From: [REDACTED]
Sent: 20 February 2019 10:45
To: NorfolkVanguard@pins.gsi.gov.uk
Subject: EN010079: Norfolk Vanguard Updates Deadline 3

To Planning Inspector...Norfolk Vanguard

My Registration Identification No. 20012530.

Title: Viewpoint 9:  
St Andrews Lane, Necton

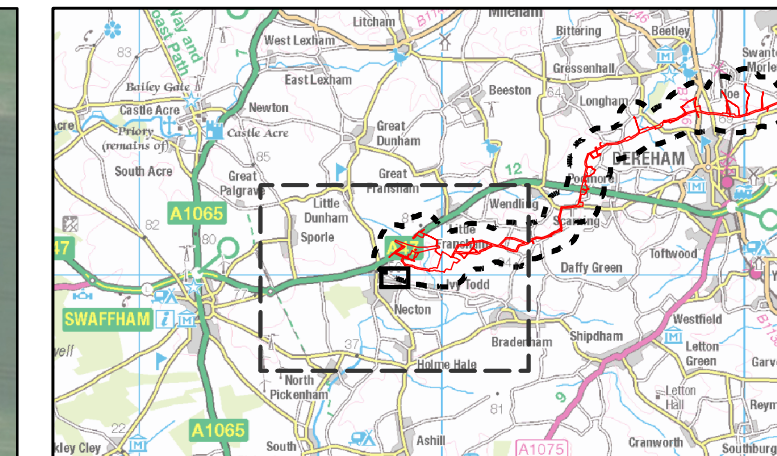
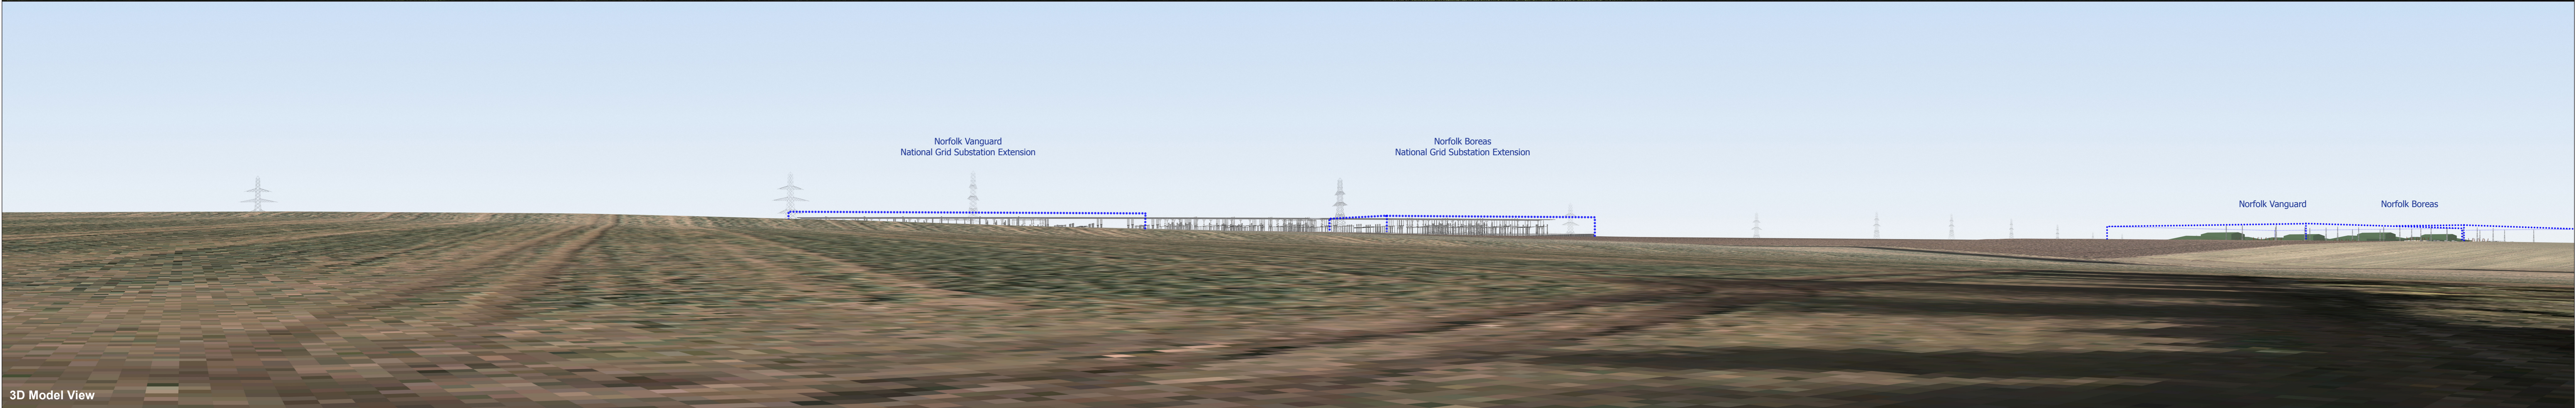
It would appear the developer is being disingenuous in their other choices, such as 'Location 8' (St.Andrews Lane) which it seems has been carefully chosen, laying behind a natural rise in the ground and whilst the National Grid substation extension may be seen from there, to get an idea of the impact of the substations on the residents of St.Andrews Lane you would need to see the view from the rear gardens further down the lane (on the north-east side of the road) and of course from their rear upper floors where they will all see the substations.
